Recommendation Report for Planning Permission

REF NO: R/15/15/PL

LOCATION: 1 Merton Avenue
Rustington

PROPOSAL: Proposed installation of 2 no. velux style windows to east and west roof elevations

proposed side elevation (East)

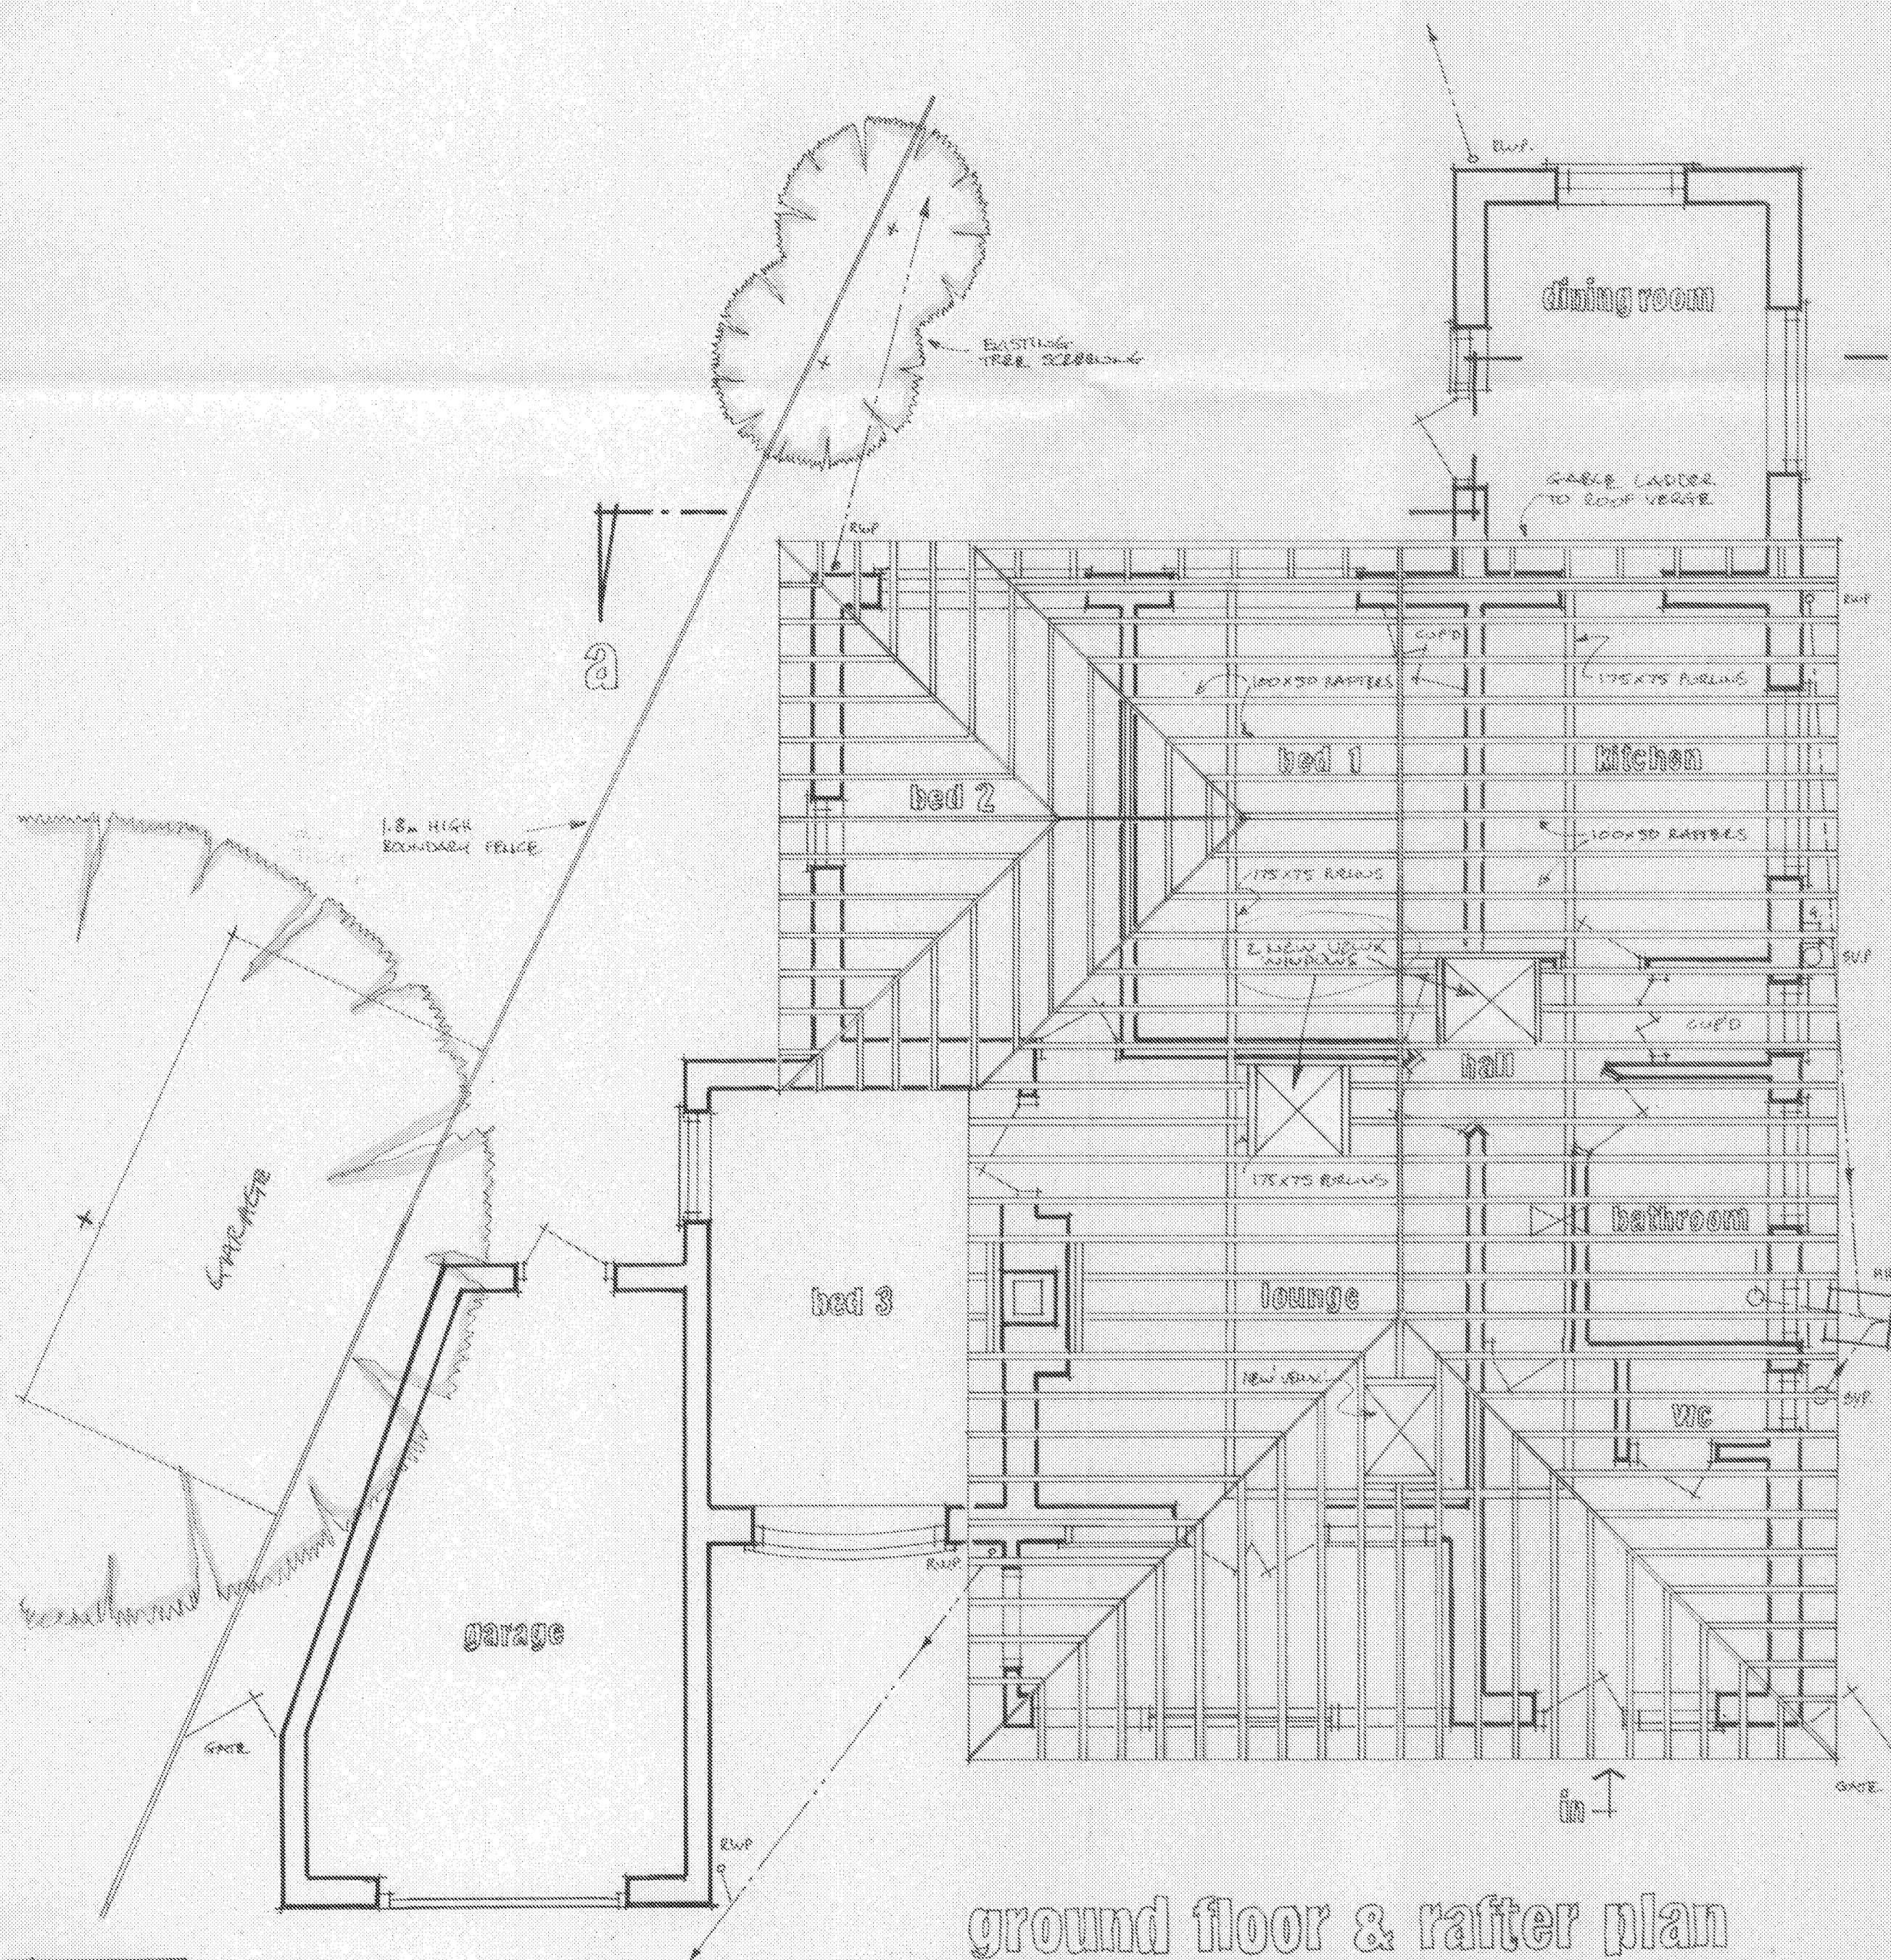
(i) The proposal, in respect of the east facing Velux style window, would result in a severe loss of privacy for the occupiers of Nos. 5 and 7 Amberley Road and No. 3 Merton Avenue, by reason of overlooking to an unacceptable degree. This would most certainly adversely affect the peaceful enjoyment and amenities of the occupiers of the aforementioned properties, and would be out of keeping with the street scene and surrounding area overall.

The proposed roof lights will be located upon the side elevation of the property and as such will have the potential to create overlooking of the adjoining properties. The proposed window upon the eastern elevation which faces no. 3 Merton Avenue will look out on the blank roof slope of this neighbouring property. The roof light will give rise to oblique views into the private rear garden of no. 3 and as such it has been determined to give rise to harmful overlooking contrary to policy GEN7(iv) of the Arun Local Plan.

(WEST) SIDE ELEVATION - PROPOSED

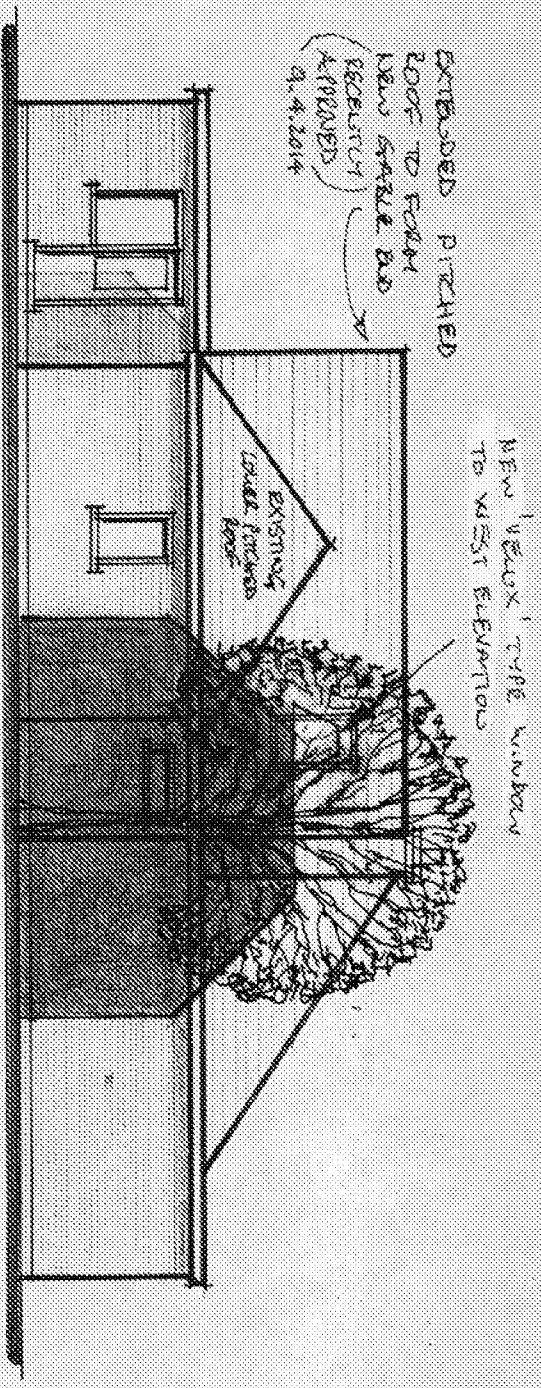
- The proposed western roof light will over look the rear garden, patio area, bedroom, kitchen and sun room of 7 Amberley Road.
- Loss of Privacy at 3 Merton Avenue.
- Design not in keeping with surrounding area.

The roof light on the western elevation will face towards 5 and 7 Amberley Road and is not deemed to cause any adverse overlooking of 7 Amberley Road due to the presence of a garage and tree screening along the western boundary. However, the proposed window has the potentially to cause unacceptable overlooking of the private rear garden of 5 Amberley Road and as such this window is deemed to be in conflict with policy GEN7(iv) of the Arun District Local Plan and Policy 2 of the Rustington Neighbourhood Plan.
